Our ref: DOC21/1039608
Senders ref: SSD-11070211

Subject: EES comments on Response to Submissions for New Public School in Mulgoa Rise – 1-23 Forestwood Drive, Glenmore Park – SSD-110702211

Subject: EES comments on Response to Submissions for New Public School in Mulgoa Rise – 1-23 Forestwood Drive, Glenmore Park – SSD-110702211

Drawing Title
PLANTING PALETTE

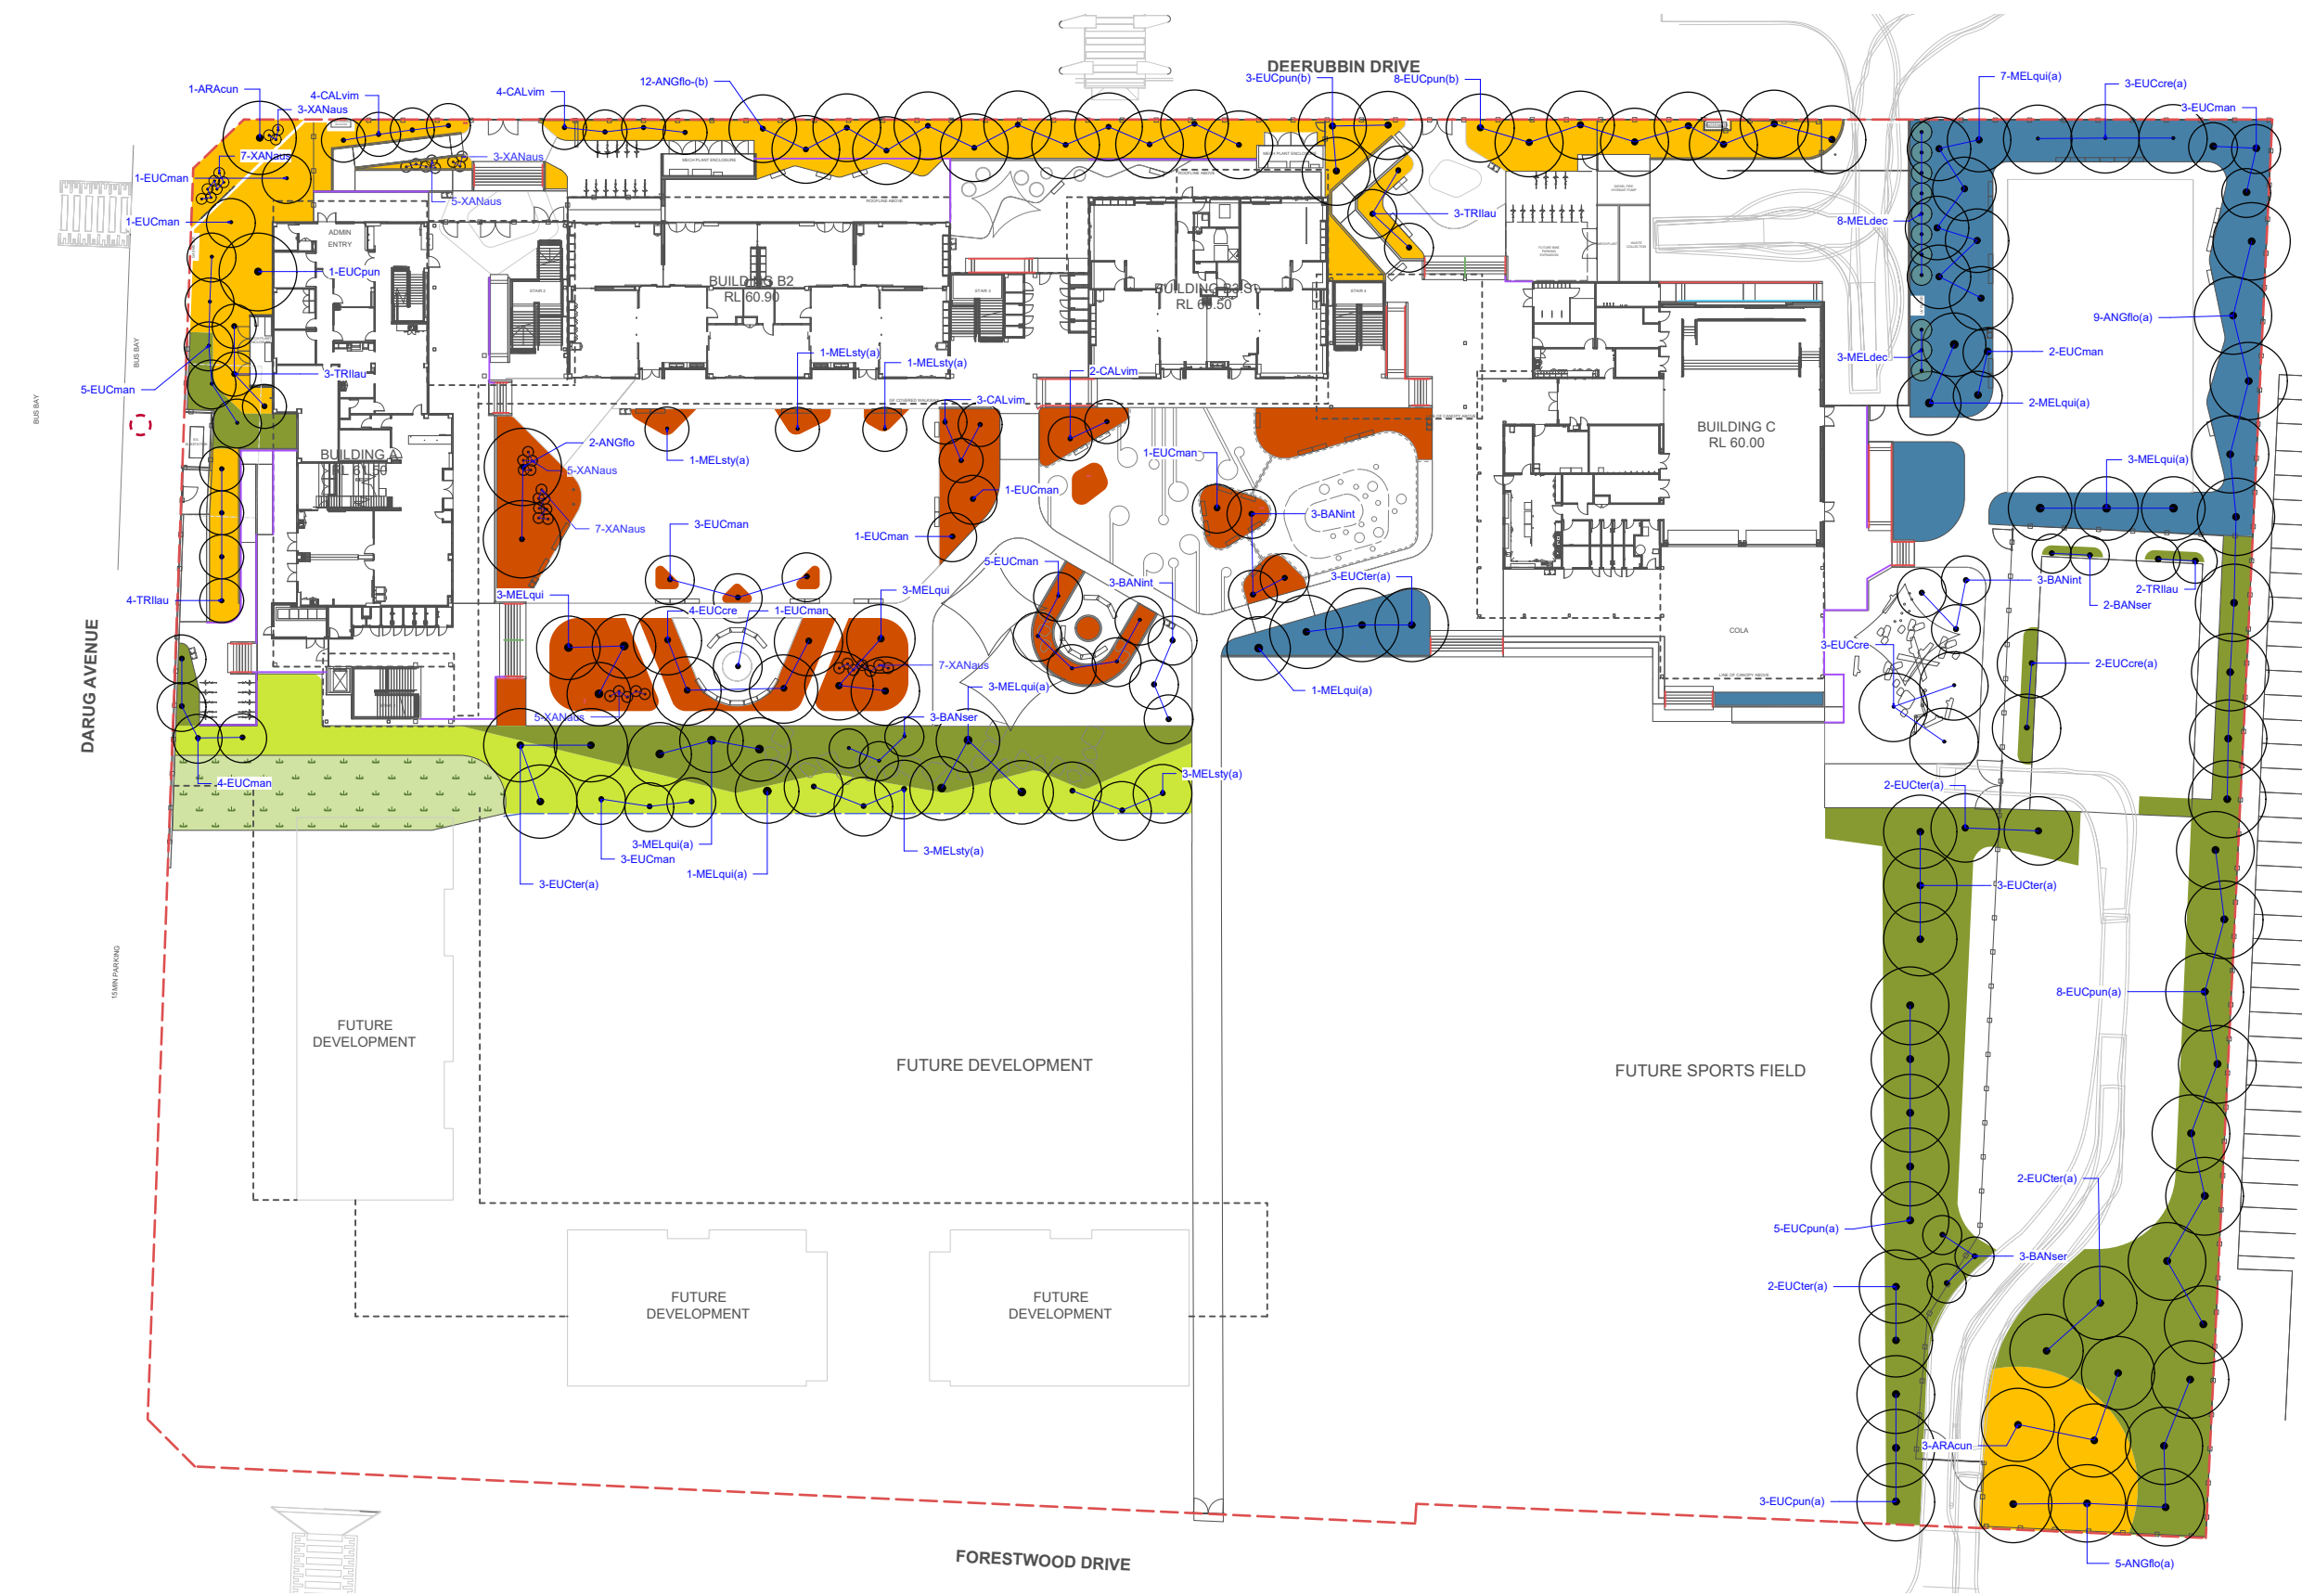
In response, the RtS states “where possible species from the local plant communities have been included in the design (subject to availability & EFSG requirements). To supplement these species local natives or robust native species have been selected to suit the site conditions”. The RtS does not specifically identify which native vegetation community once occurred on the site, or in the locality and it is unclear why the local native species need to be supplemented by other ‘robust native species’.

EES notes in the RtS that Council recommended alternative tree species be identified that are more consistent with Shale Plains woodland. It is noted the Planting Schedule in Appendix C identifies plant species that are from Cumberland Plain Shale Woodlands and the Shale-Gravel Transition Forest Community but the Planting Schedule also includes numerous species that are not identified from these communities.

EES repeats its recommendation that a condition of consent is included for any planting / landscaping associated with the SSD to use a diversity of local provenance native trees, shrubs and groundcover species (rather than exotic species or non-local native species) from the relevant native vegetation community that once occurred in this locality (see below). EES recommends an appropriately qualified bush regenerator is engaged by the proponent to provide advice on appropriate local native species that can be used on the site and to revise the Planting Schedule.

- ***Any planting/ landscaping associated with the SSD shall use a diversity of local provenance native trees, shrubs and groundcover species (rather than exotic species or non-local native species) from the relevant native vegetation community that once occurred in this locality.***
